From: Landuse Planning <LandUsePlanning@tii.ie>
Sent: Tuesday 6 January 2026 10:30
To: SIDS
Subject: Proposed substation, associated 220kV or 110kV underground grid connection in Co. Carlow -Ballyloo Solar Farm Ltd.- Case reference: ACP ref. VA01.323860_TII ref. TII25-134006
Attachments: TII25-134006 - 220kV AIS 220kV GIS substation or a 110kV substation, 220kV or 110kV underground grid connection and ancillary works, Ballyloo Solar Farm, Co. Carlow - Case ref. VA01.323860_issued 06.01.2026.pdf

TII25-134006

RE.: Proposed 220kV AIS/ 220kV GIS substation OR a 110kV electricity substation, associated 220kV or 110kV underground grid connection and ancillary works located in the townlands of Ballyloo, Knockbower, Linkardstown, Kilballyhue, Graiguenspiddoge, Castletown, Moyle Big, Leagh or Ballybeg, Kellistown West & Kellistown East, Co. Carlow.

Applicant: Ballyloo Solar Farm Limited

Figure 11: HDD under L30504 and N80

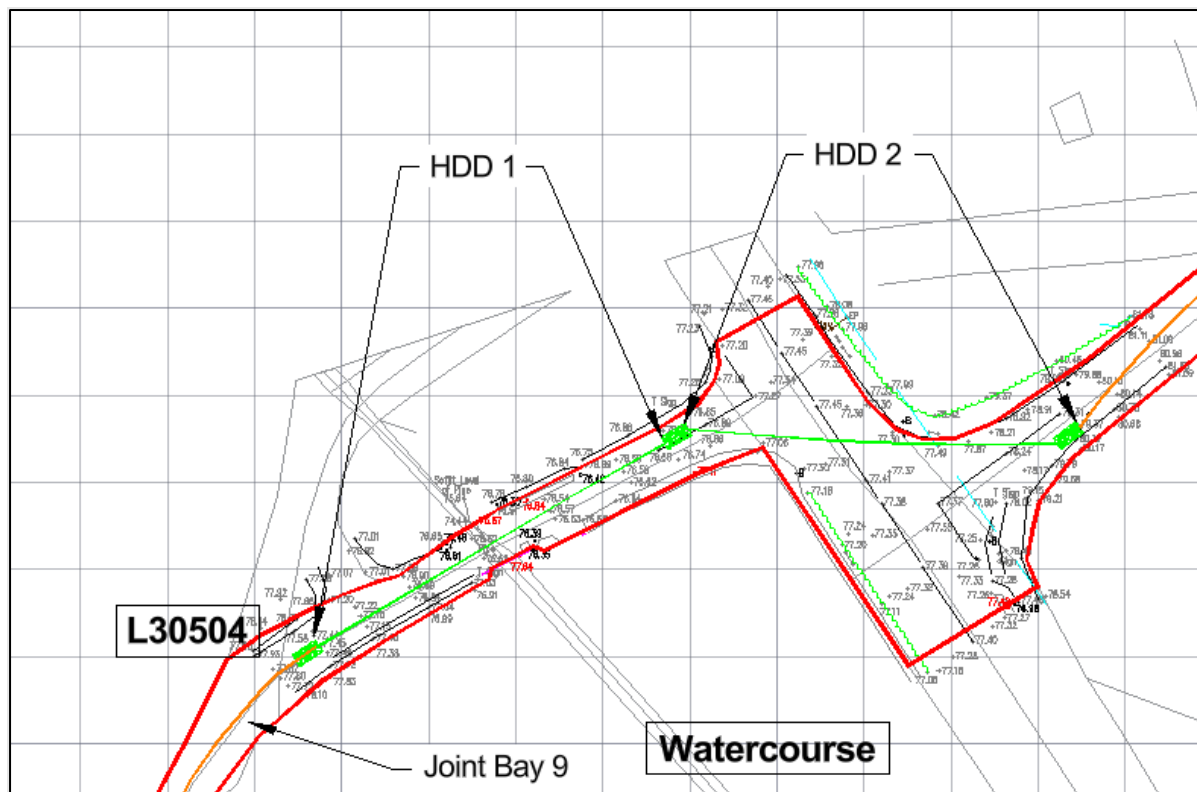
- Submitted drawing entitled *Overview Key Layout Plan* (Drawing No. *BYLOO-DR-001B*) indicates *Site Layout Plan (Grid Connection Route)*, Drawing no. *BYLOO-DR-019* for the proposed N80 crossing.
- *Site Layout Plan (Grid Connection Route)*, Drawing no. *BYLOO-DR-019* indicates a proposed horizontal directional drilling "HDD 2" crossing of the N80 with launch and reception pits in the L30504 and L7148.

TII notes the description of the proposed HDD crossing of the N80 included in the submitted *Ballyloo Substation & Grid Connection - Construction Methodology* which includes reference to TII submissions to associated solar farms. In this regard, TII notes commitment to consultation with TII in the preparation of a Construction Traffic Management Plan (CTMP) and the preparation of *"detailed Method Statements for each section of the cabling"* by the contractor and appointed site manager.

- Prior to commencement of development, and the proposed construction method statement for the section of cabling crossing the N80 shall be submitted for the written agreement of the planning authority subject to the written agreement of TII which shall include details demonstrating compliance of works on, or in the vicinity of the N80 with TII Publications.
